**Re:** 24-FRM-051  
Structural Analysis  
50 Alban Row  
Fuquay-Varina, NC 27526

At your request, the plans were reviewed for the above referenced single family residence renovation under construction to address two framing concerns noted by the inspector.

CONVERTED ATTIC FLOOR FRAMING PLAN PLAN NORTH
SCALE: 1/4"=1'-0"

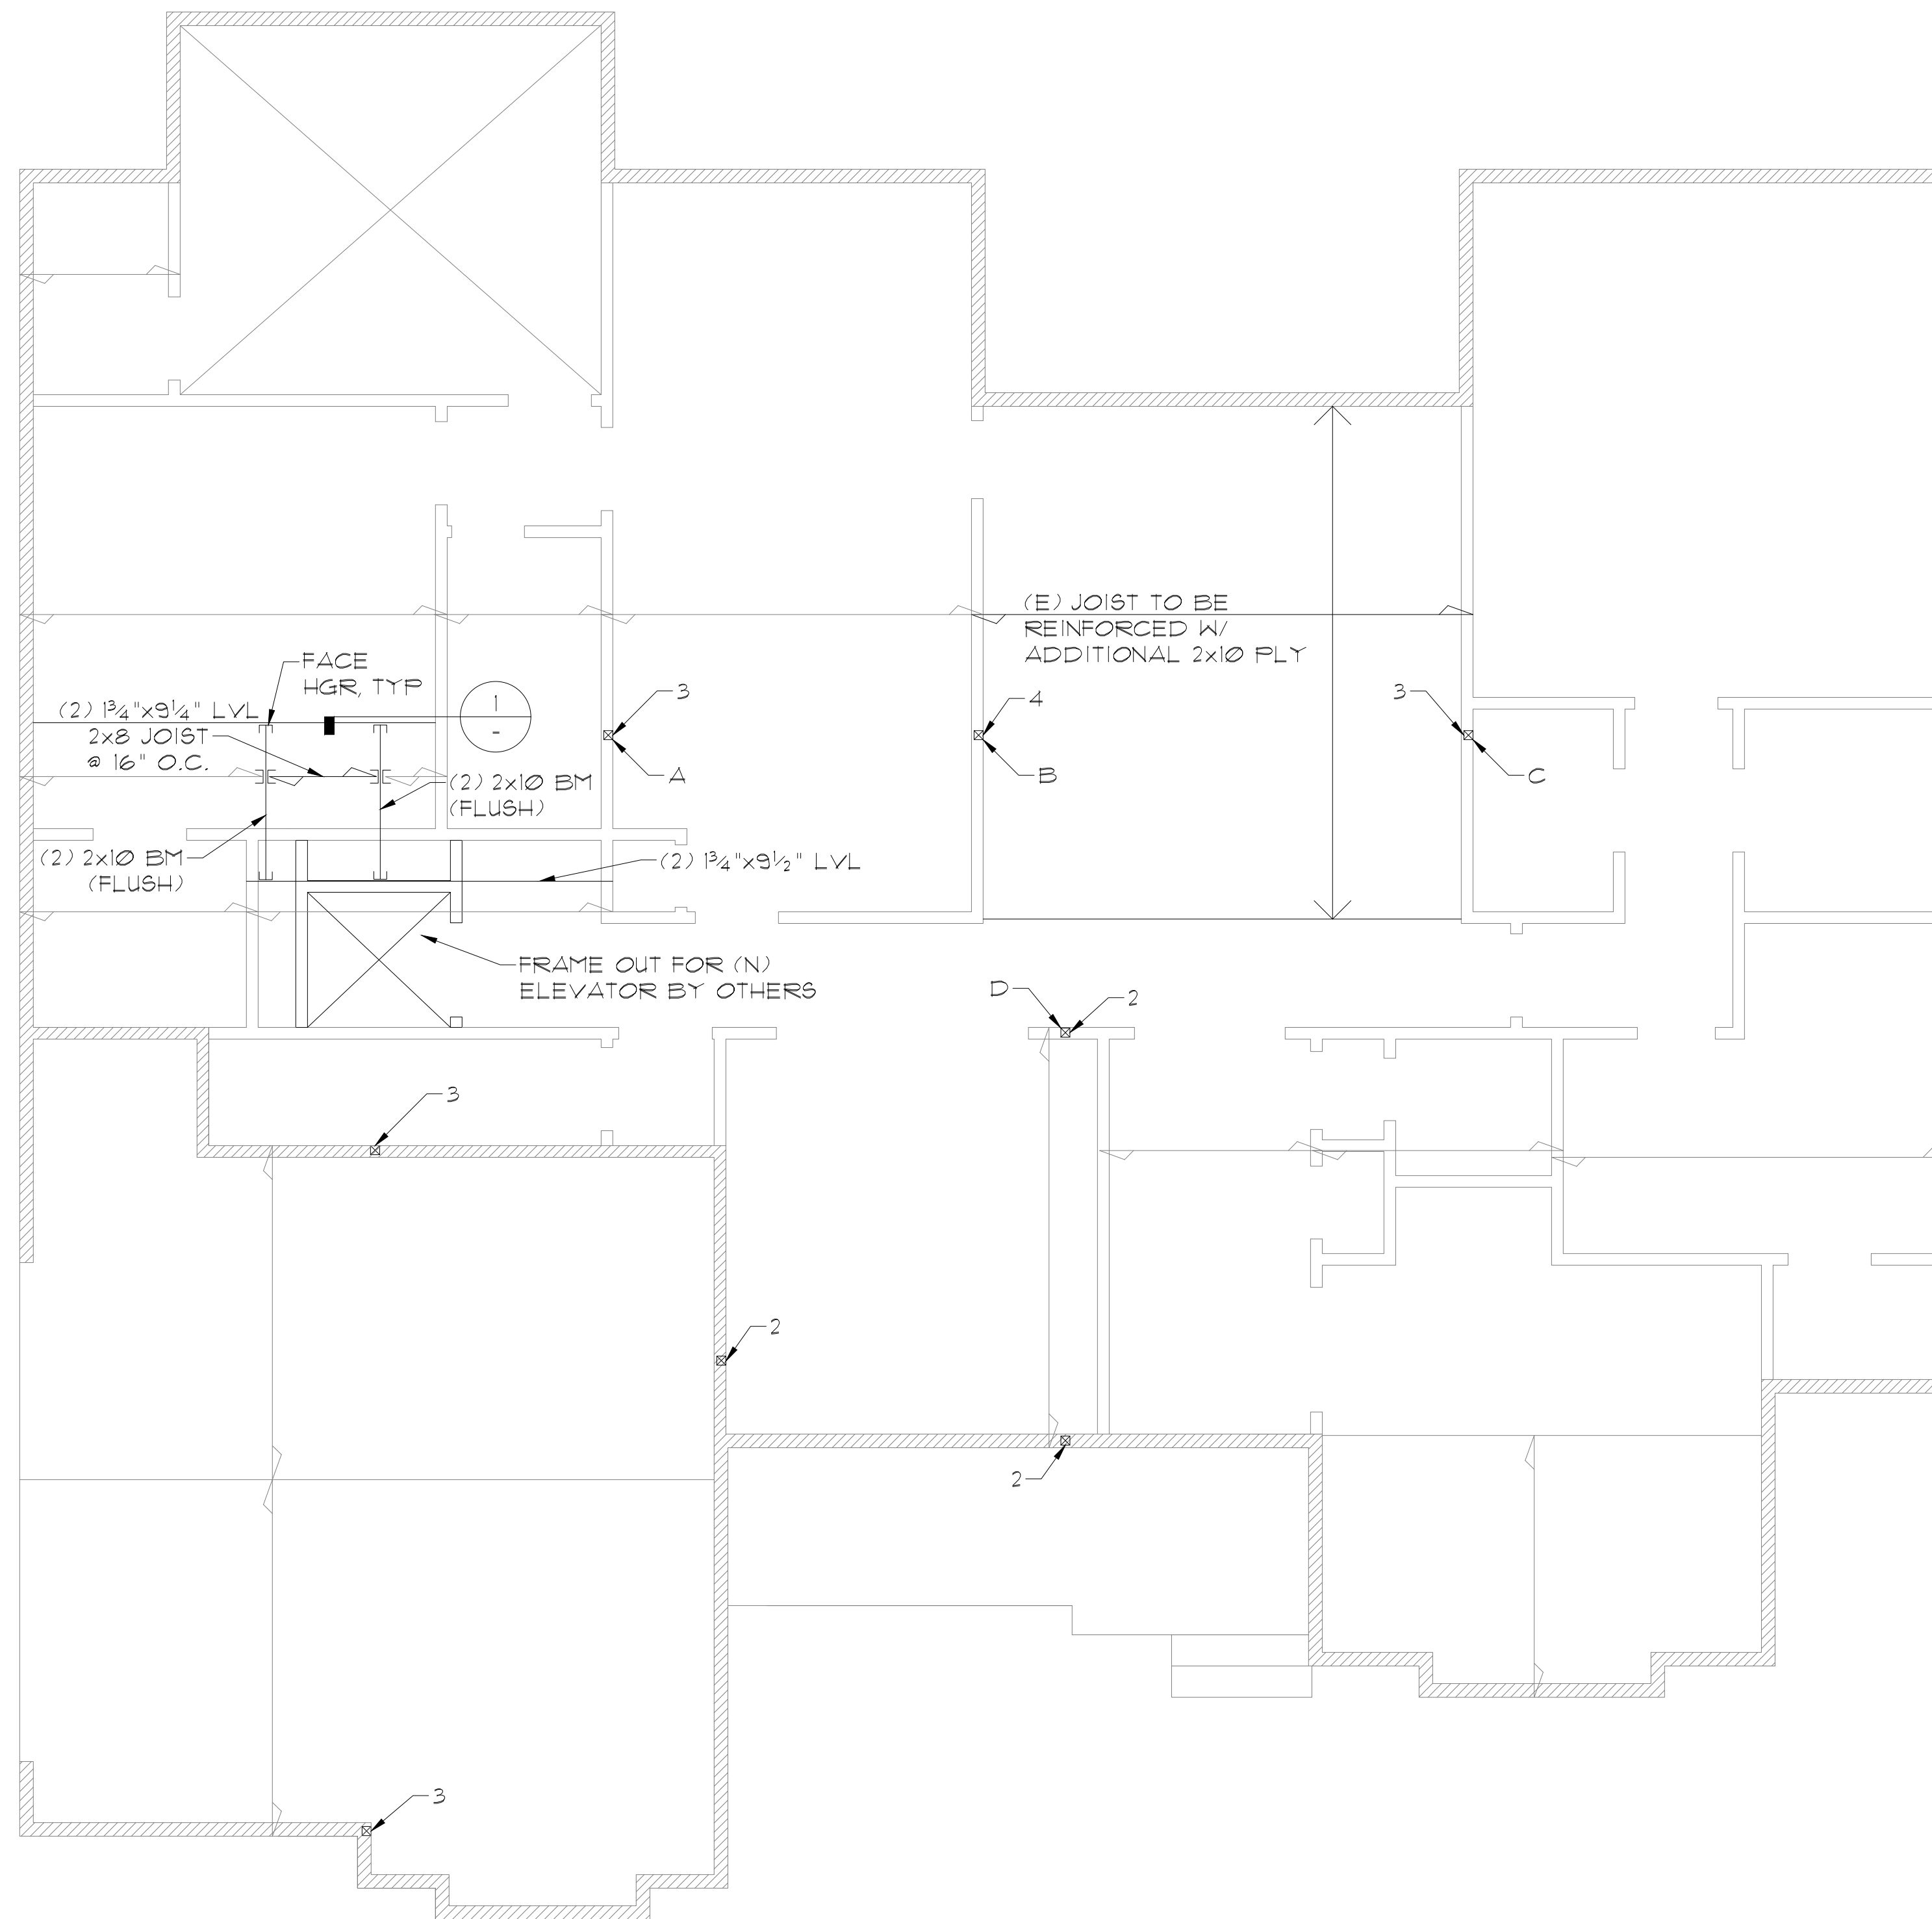
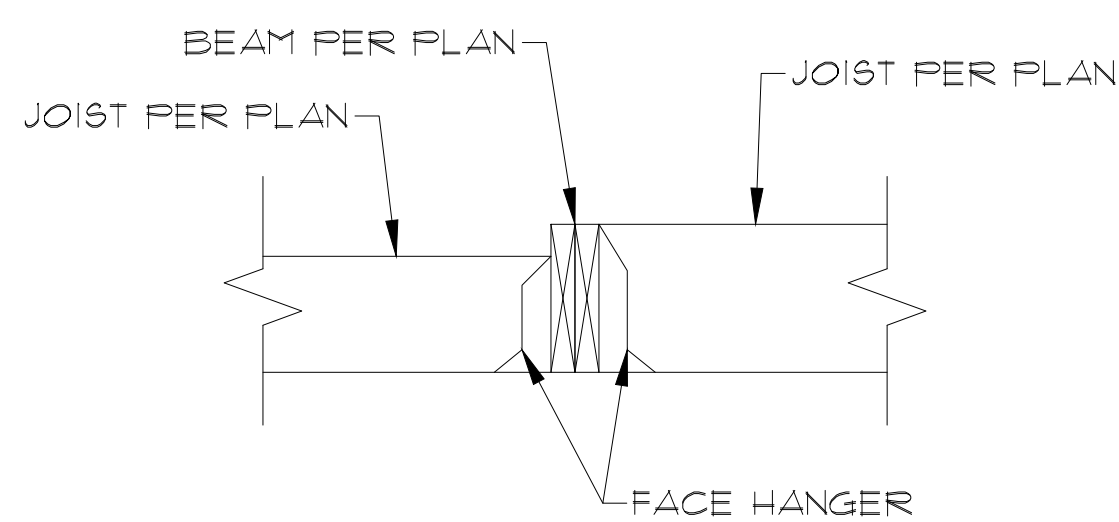
1. You indicated the plan specified double rafter above the wall between the playroom and bedroom was not installed. You also indicated the plan specified knee wall on top of the noted wall was not installed.
2. You indicated a Schluter-Shower System will be installed to create a recessed curbless shower in the upstairs ADA bathroom in lieu of framing out the shower with flush beams and installing 2x8 floor joists beneath the shower per plan.

1. Review of the plans revealed the wall between the playroom and bedroom to be a shear wall, requiring bracing at the top. The knee wall is to be framed on top of the noted wall per plan. In lieu of the double rafter, 2x8 blocking spaced 16" o.c. is to be installed between the adjacent rafters. Blocking is to be fastened to the adjacent rafter at each end with (2) 16d nails and to the double top plates of the knee wall with (3) 8d toe nails. See detail 1 on sheet SP2.0 and note D on sheet S4 for additional information.
2. The plan specified flush beams framing out the shower and 2x8 floor joists are not required. The Schluter-Shower System is to be installed per the attached detail.
